Our Ref: LY/5/19/TC

**Town & Country Planning Act 1990 (as amended) s211 Notice
Application for Prior Notification of Work to Tree(s) in a Conservation Area**

Development Crown reduction to 25 No. Leylandii, Fell 1 No. Letlandii and Crown reduction to 1 No. Silver Birch tree within the Lyminster conservation area.

Location Keymers Orchard Lane Lyminster

Keymers
Orchard Lane BN177GL

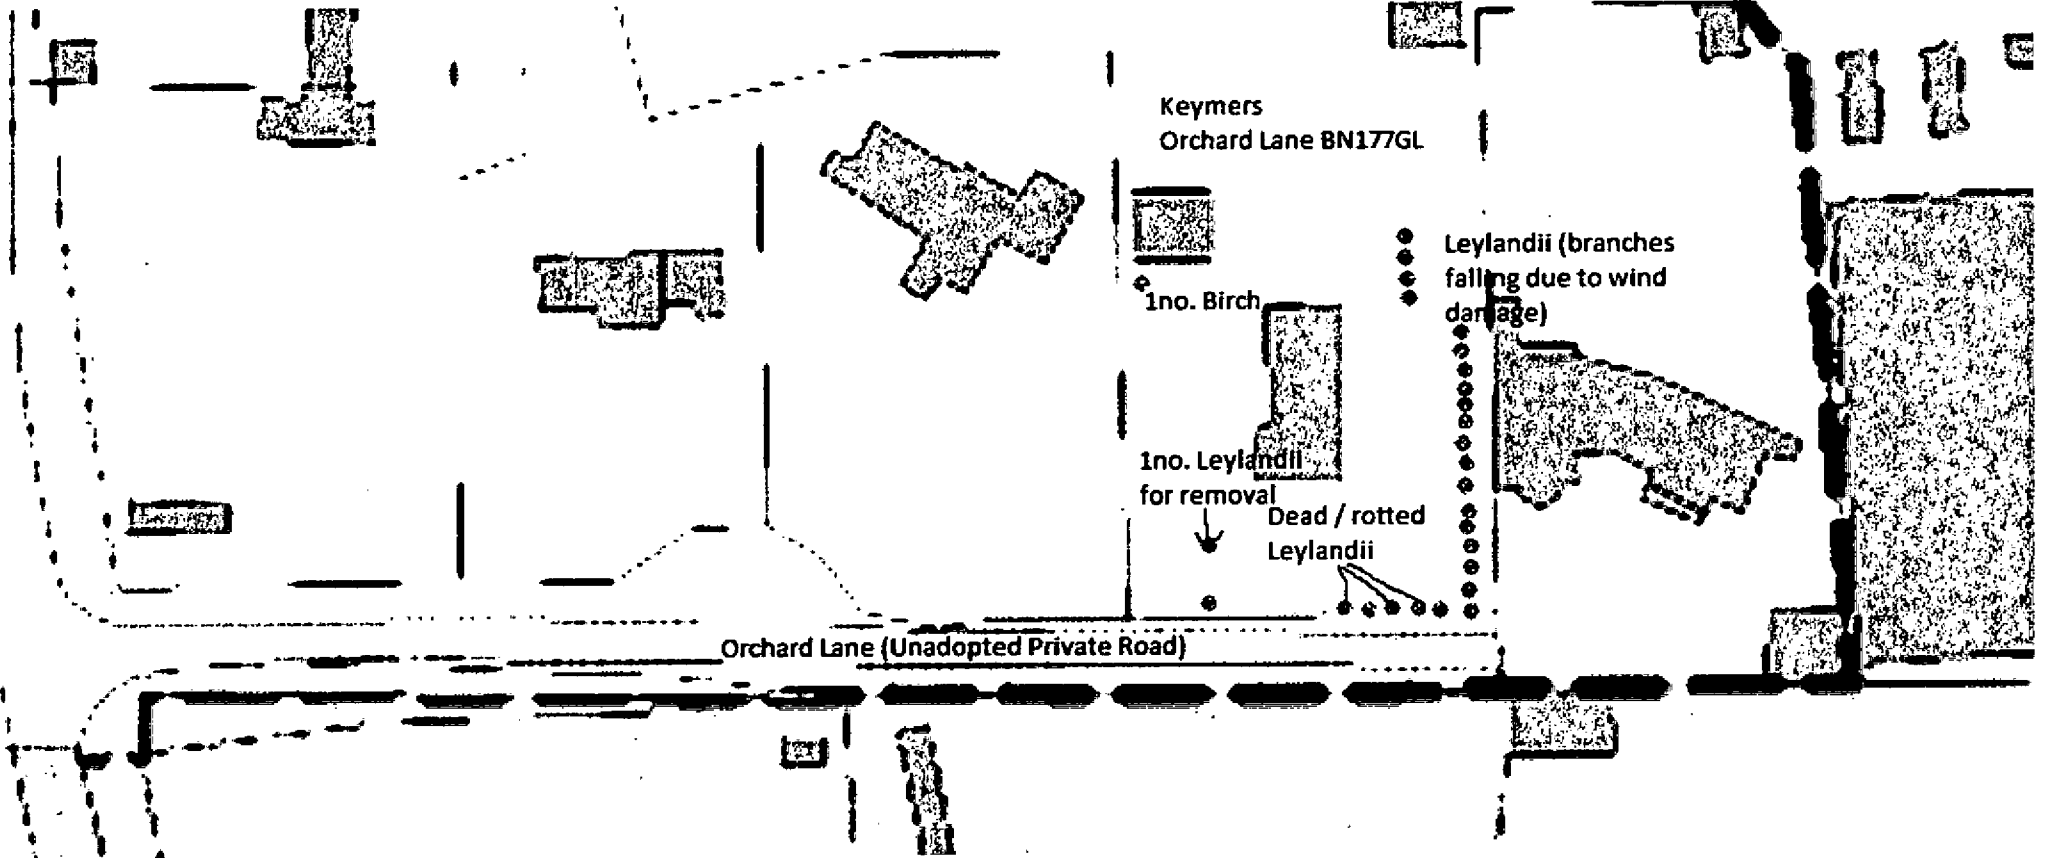
Please confirm the reduction in metres to 1 No. Silver Birch tree.

Please confirm the reduction in metres to each of the 25 No. Leylandii trees.
